**Consultation Response from KC,
Ecology Unit**

2020/94203 Clough House, 236, Leeds Road, Birstall, Batley, WF17 0HW

Outline application for demolition of dwelling and associated outbuildings and the erection of 30 dwellings

Responded:26/01/2021

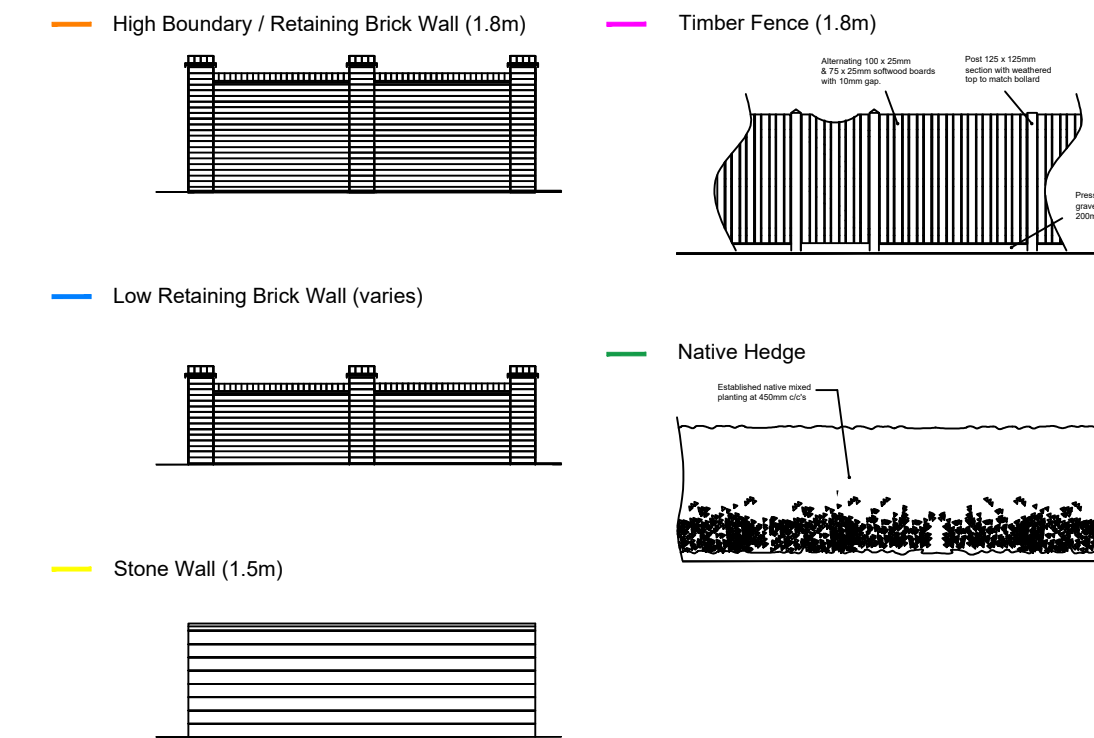
The Kirklees Wildlife Habitat Network (KWHN) is included within the north of the site boundary. This area is currently composed of an area of modified grassland, therefore, does not provide high value connections to the adjacent woodland habitats. However, in accordance with Policy LP30 iii development is required to *"safeguard and enhance the function and connectivity of the Kirklees Wildlife Habitat network at a local and wider landscape-scale"*. As the current plans indicate that the area of network is to be contained within the curtilage of residential gardens, the maintenance of this in the future is uncertain and is not considered enhancement therefore it is not in accordance with LP30. The inclusion of a buffer zone with suitable native tree planting to complement the adjacent woodland habitat would be considered more suitable than the boundary hedge currently proposed.

The site previously contained a boundary of mature trees to the south of the site, which appear to have been removed, consequently the remaining boundary vegetation has been classified as ornamental hedgerows with very little ecological value. The inclusion of a new native hedgerow with trees to the north and south is an improvement upon this, however it is not considered to be a biodiversity net gain based on the previously mature trees that were situated along this frontage. In addition, current layout designs indicate very little public open space with the majority of tree planting and new hedgerows situated within the curtilage of residential dwellings and the future maintenance of these is uncertain.
